3D Community Church 658 Graham Rd Sanford NC.

Permit Review Comments
5/3/24

Brad Sutton
Chief Code Official
Manager of Building Services
Harnett County Central Permitting and Inspections

**A00.04**

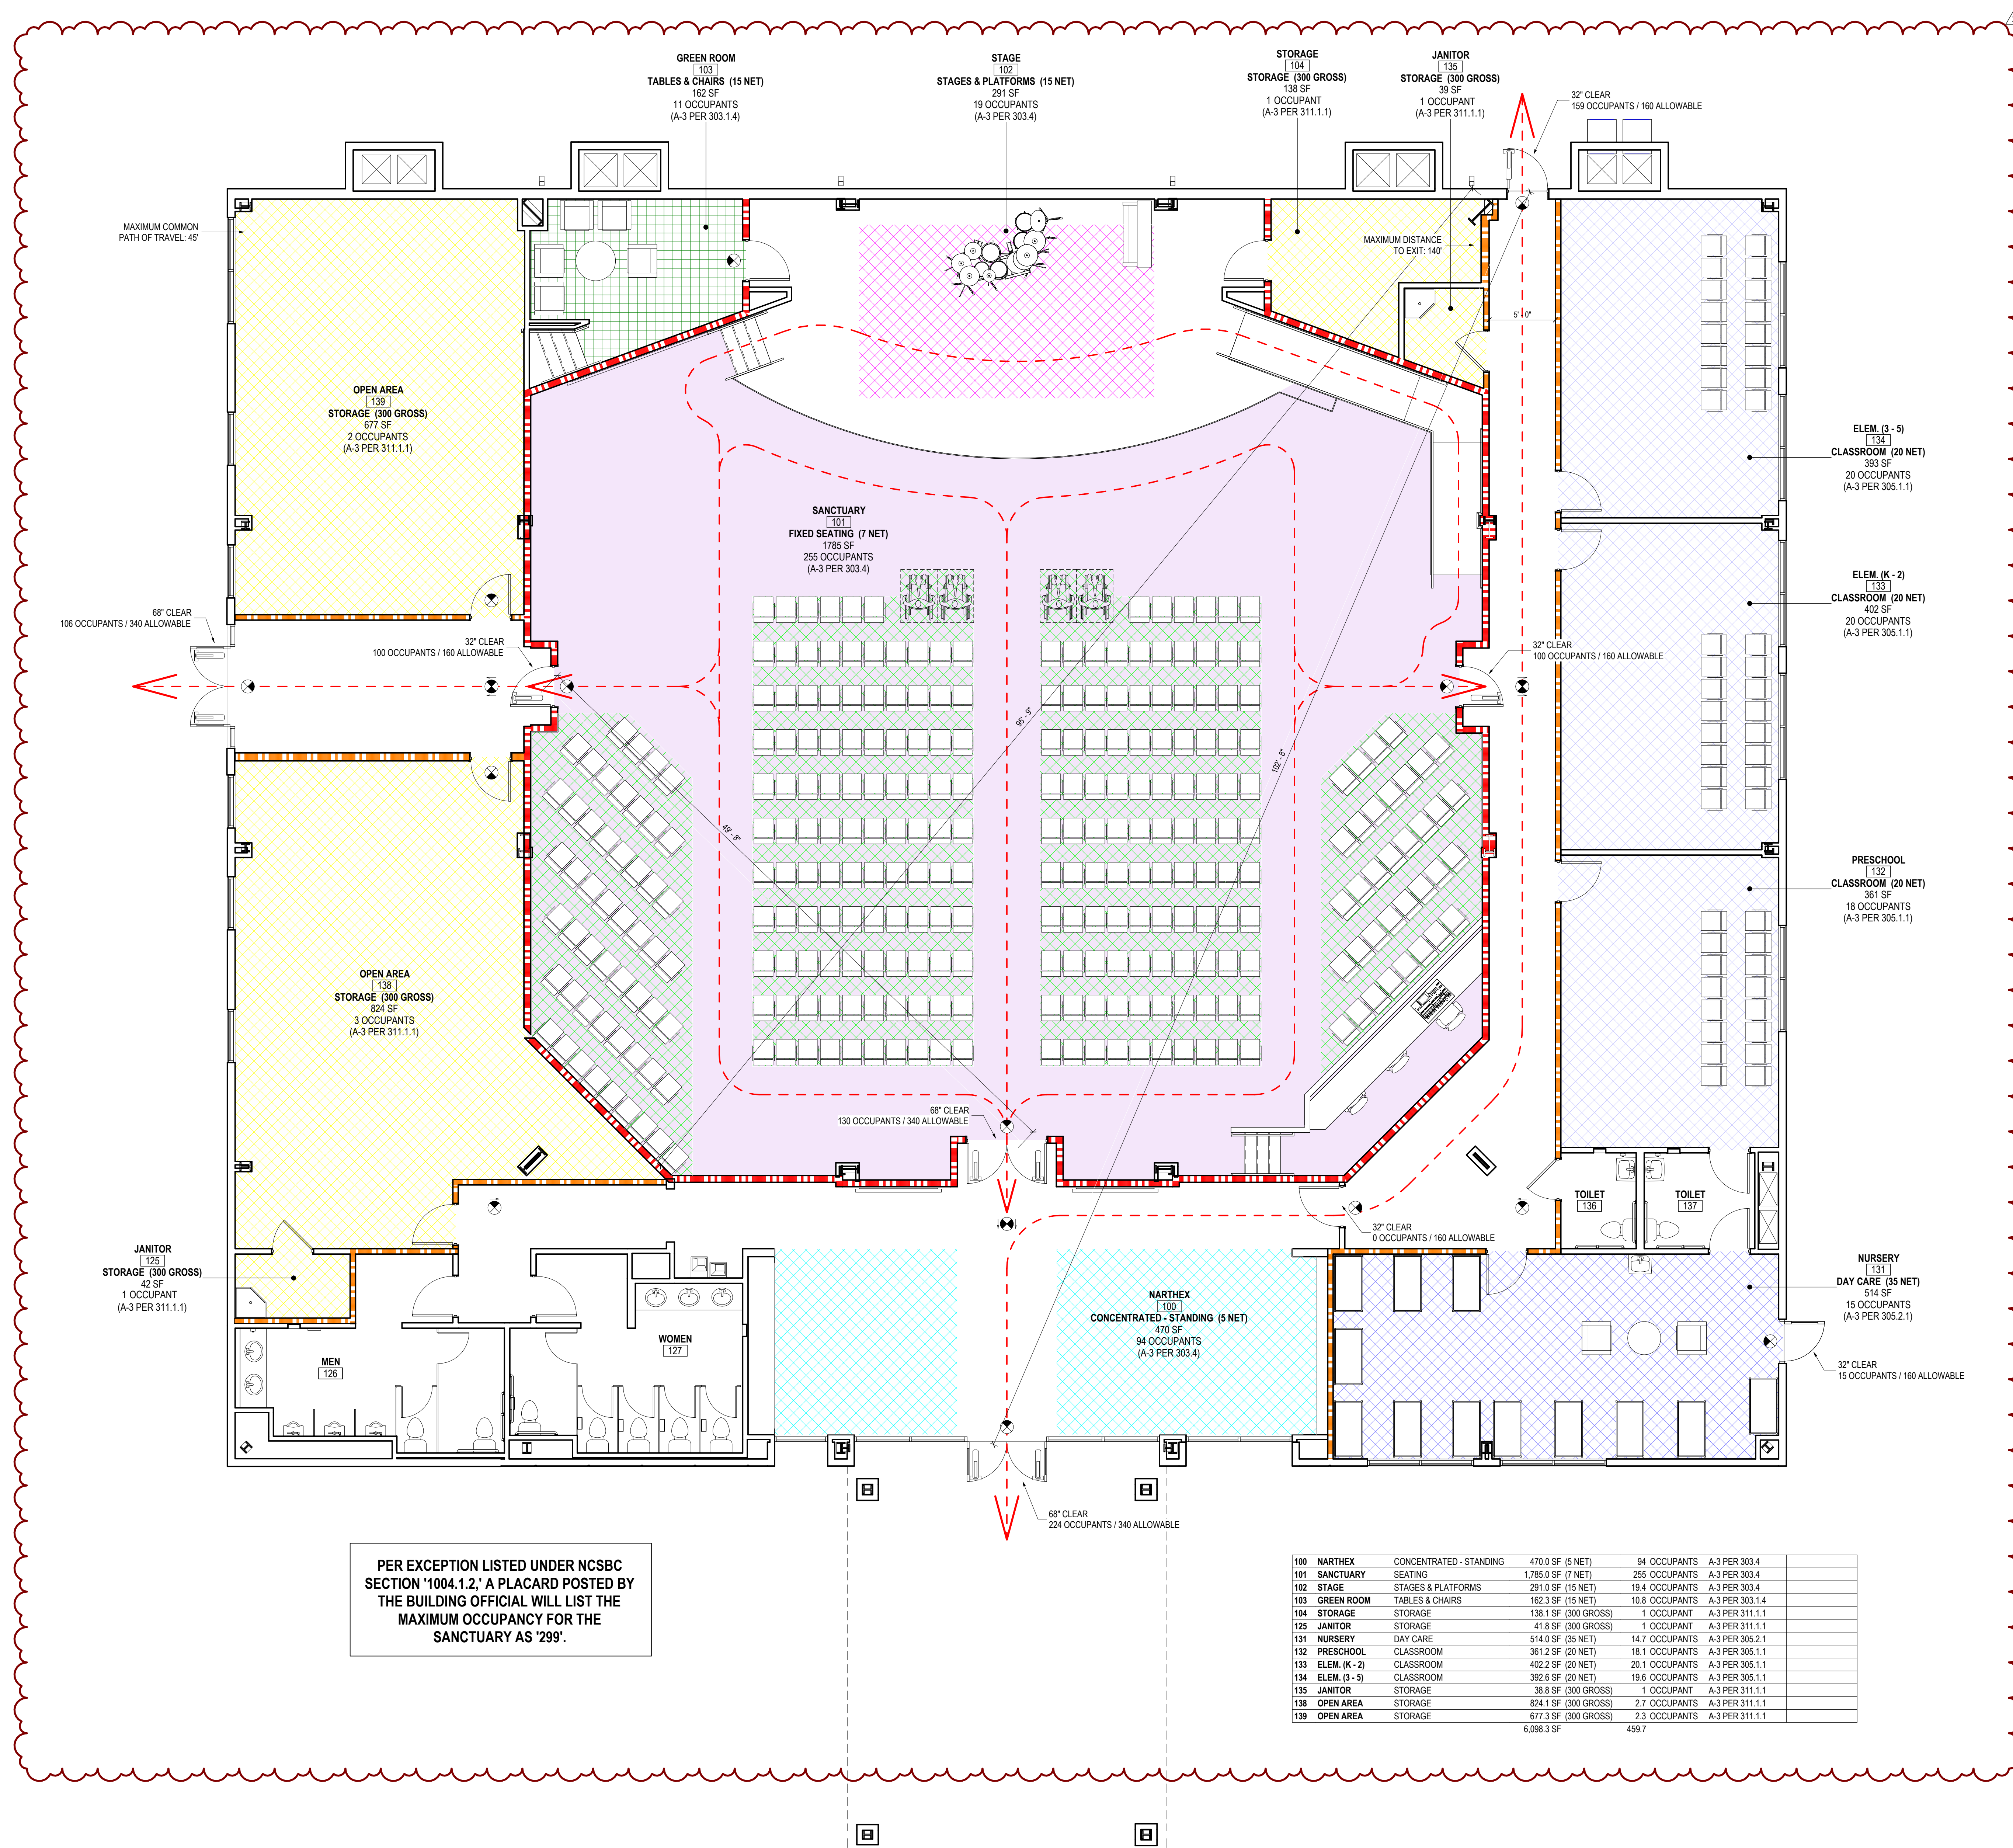
1. In order to apply the sprinkler exception of 903.2.1.3 (Ex1) you must meet two requirements.
a. Sanctuary shall be separated with 2 hour minimum fire barrier from all other occupancies. (this need to be corrected to separated mixed use)
2 hour fire barrier separation has been provided. - A00.04

b. seating shall be fixed seating only per exception 1.
Fixed seating has been noted. - - A00.04 - A02.06
2. Allowable building area calculations are incorrect on Appendix B. Group A-3 Type II NS is max. 9500 Sq ft. Provide corrected calculations showing allowable increases per 506.
Allowable building calculation has been corrected and Separated mixed use provided.

Fire Alarm System

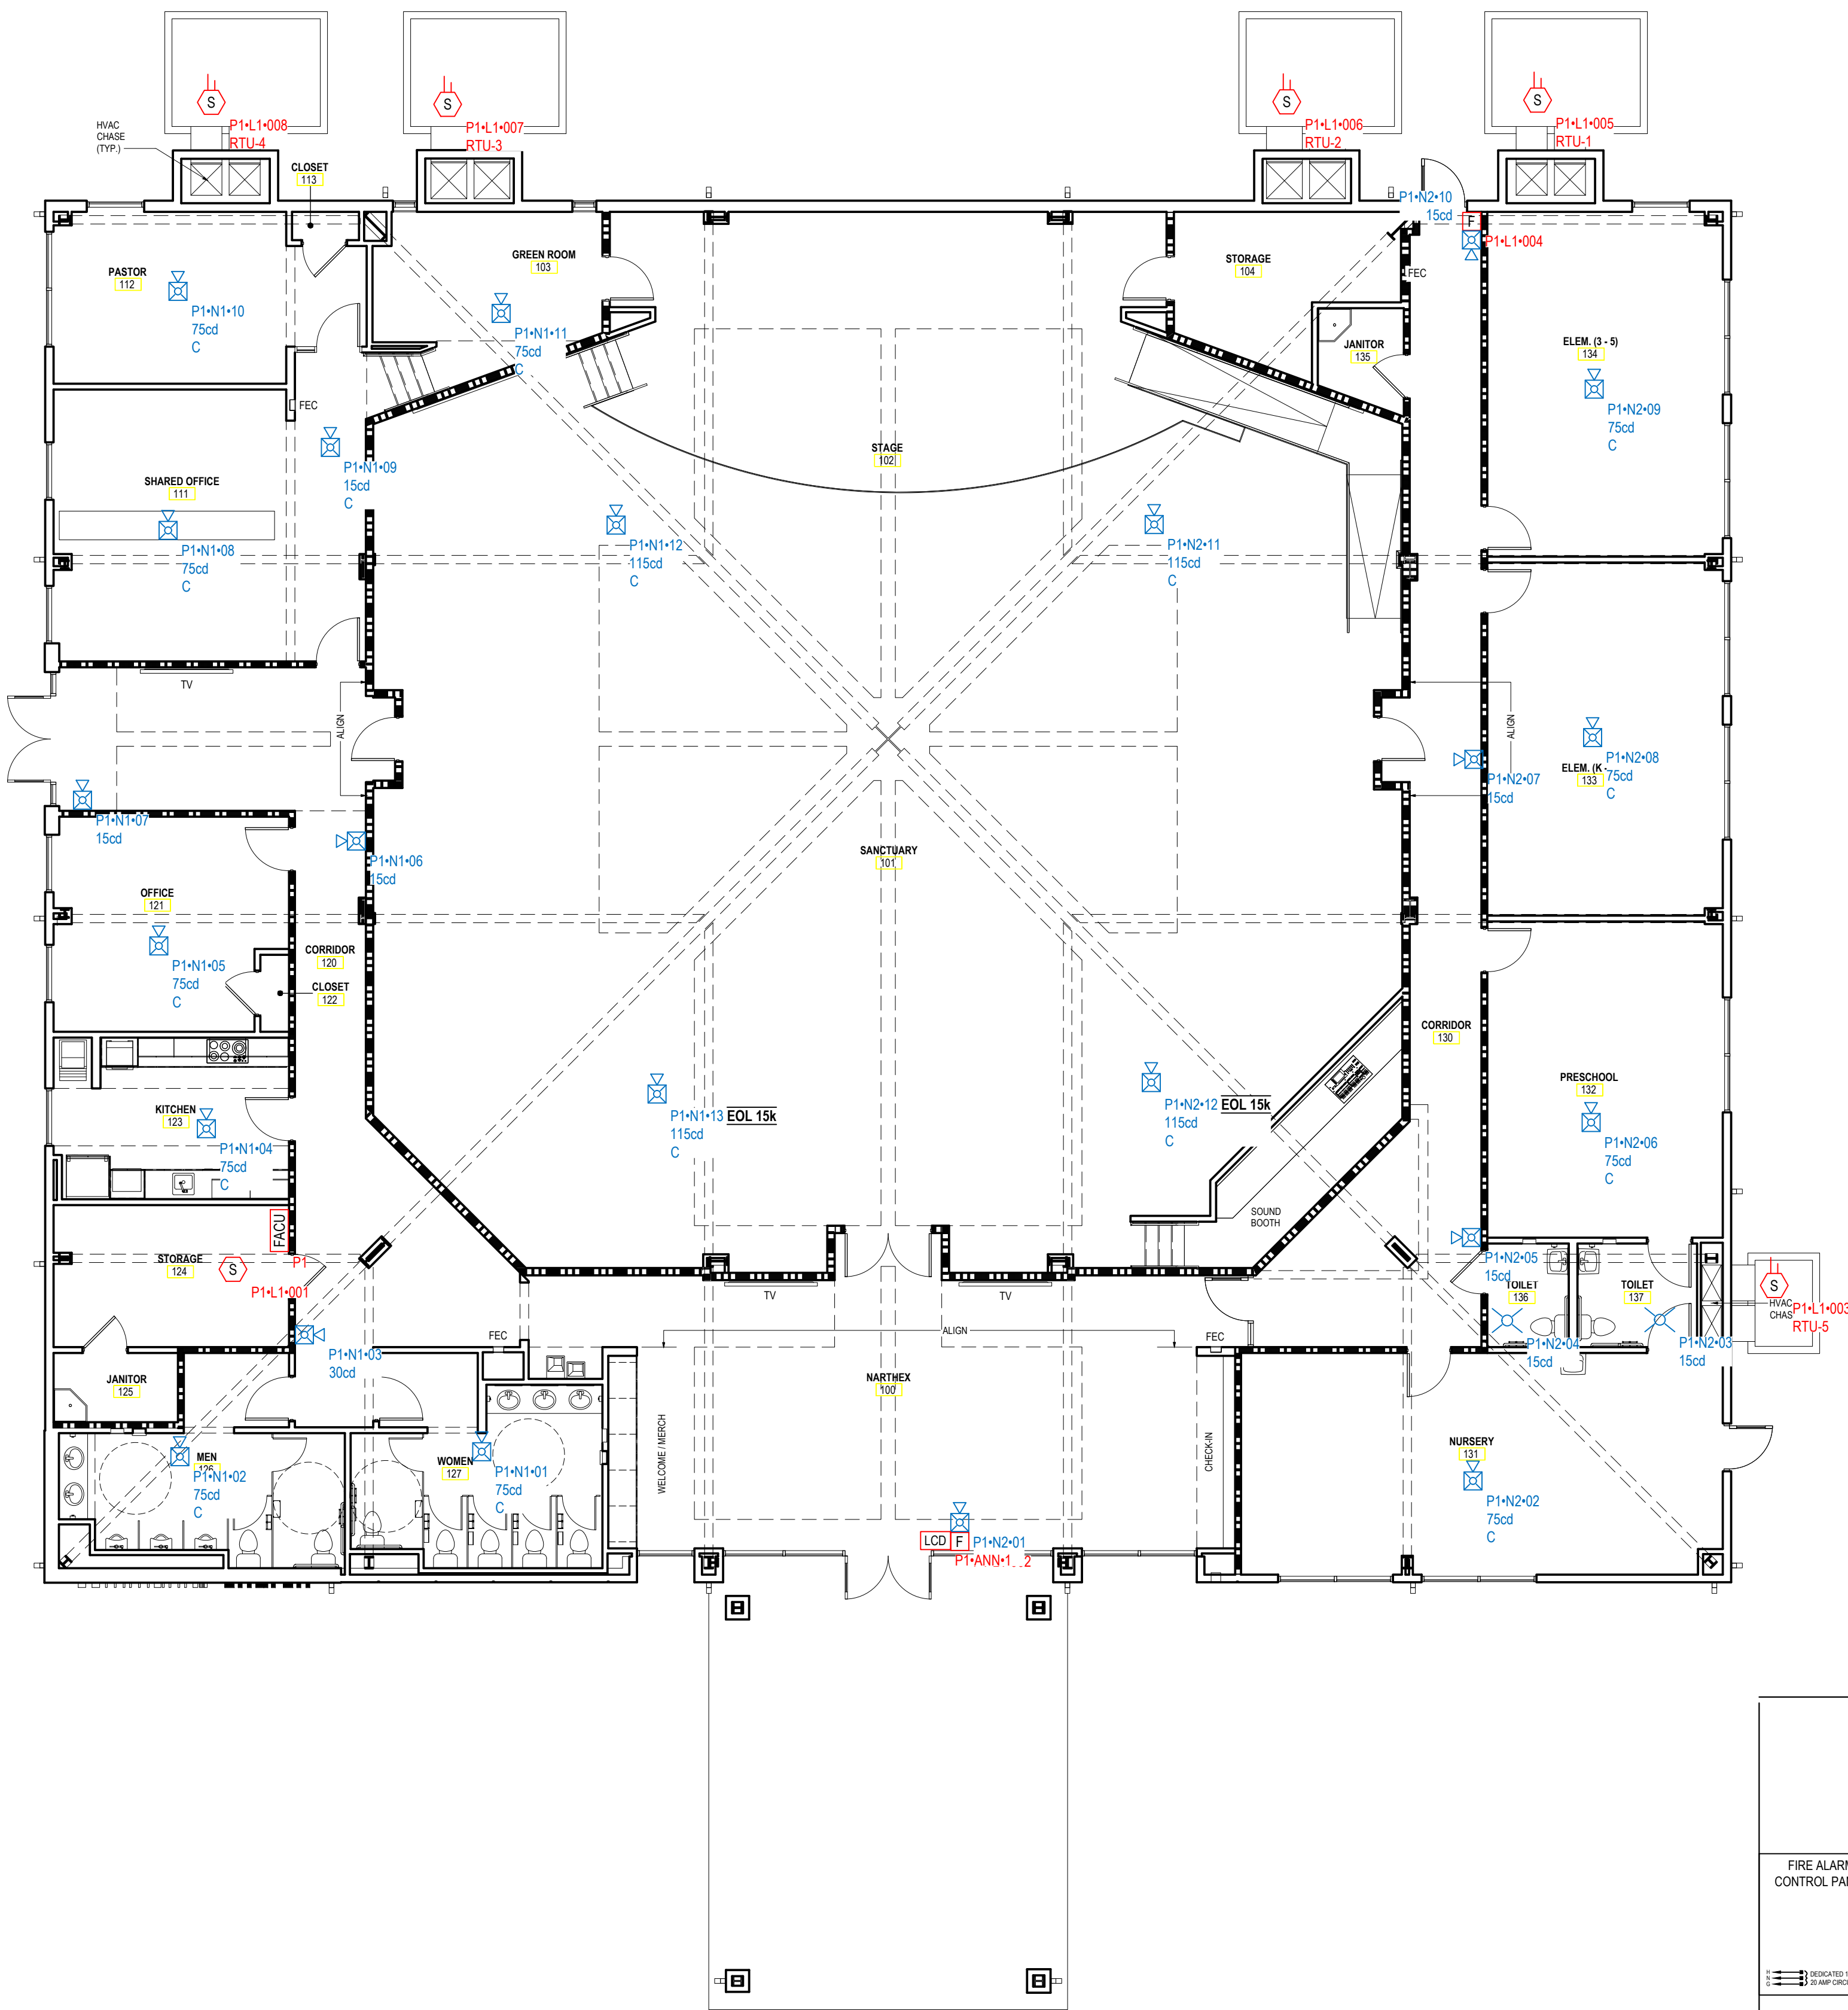
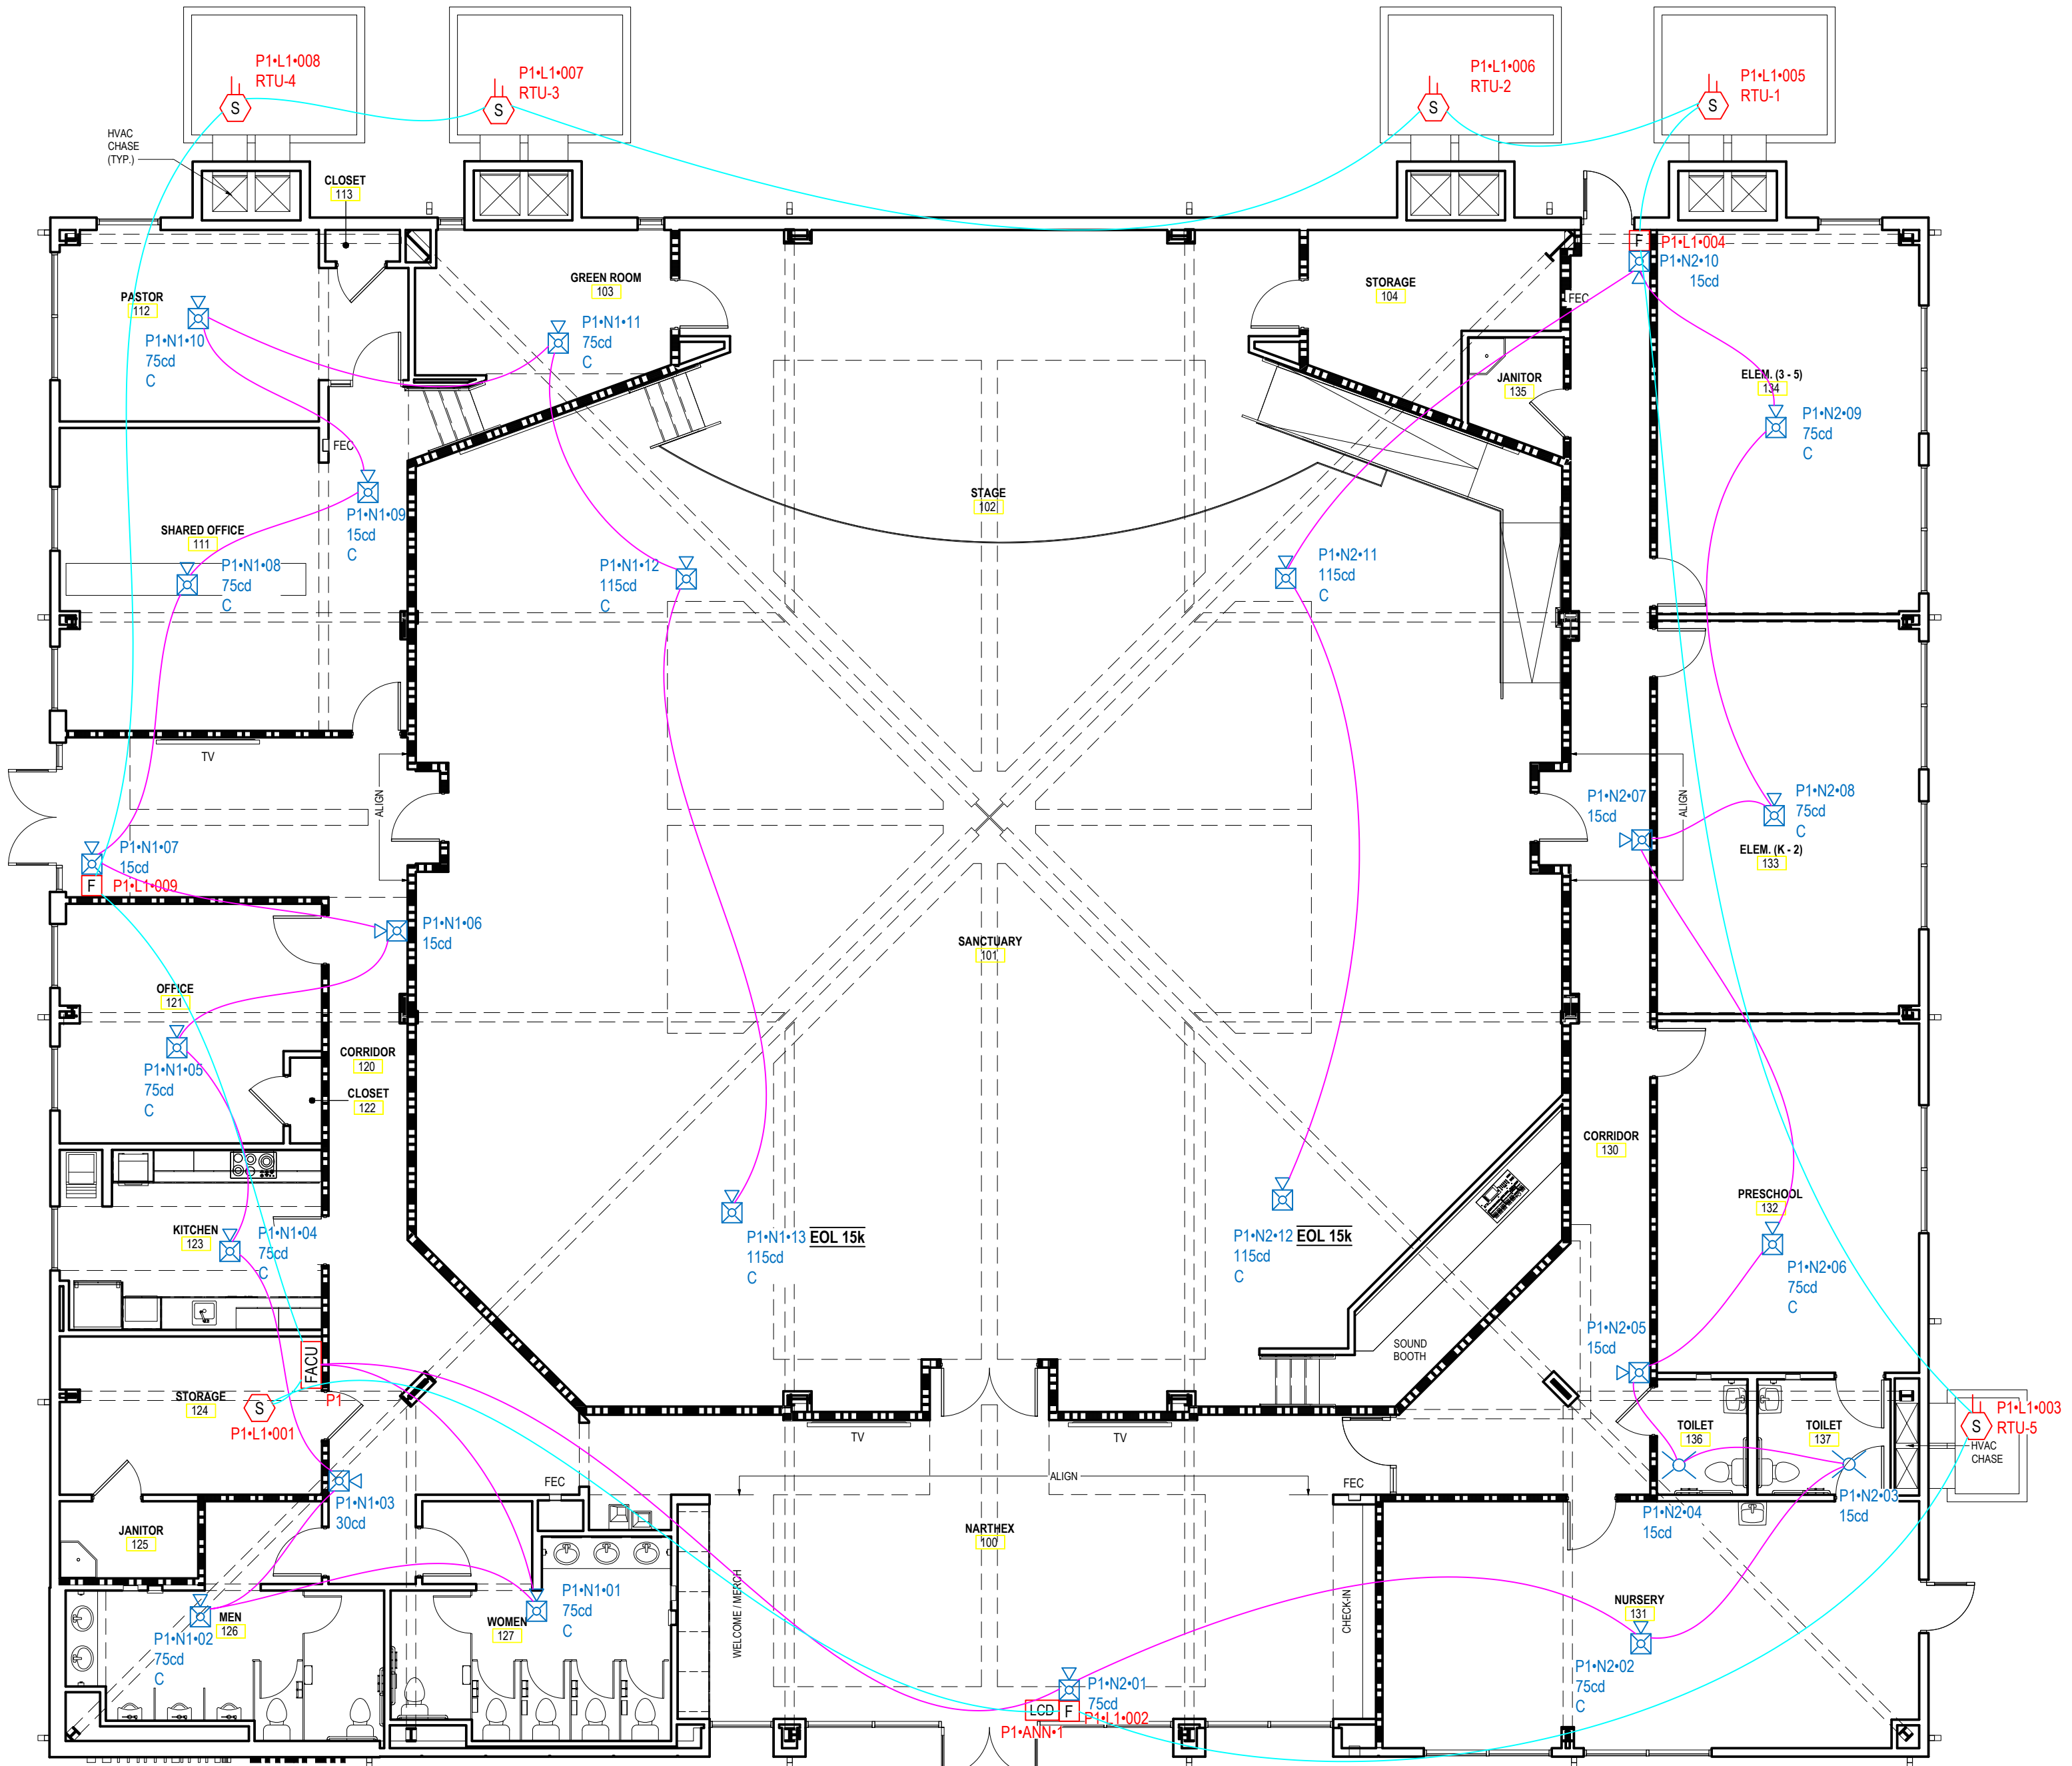
1. A full set of automatic fire sprinkler system plans need to be submitted for review.
Building is not sprinklered per exception of 903.2.1.3
2. Submit a full set of fire alarm system plans to include wiring diagram, battery calculations and spec sheets on fire alarm panel and all appliances to be installed. Manual pull station at vestibule (110) exit door not noted on the electrical plans
Fire alarm subcontractor will provide the fire alarm system plans, calculations and specs after plan review approval and before installation.
Manual pull station added to Electrical drawings. – E03.01
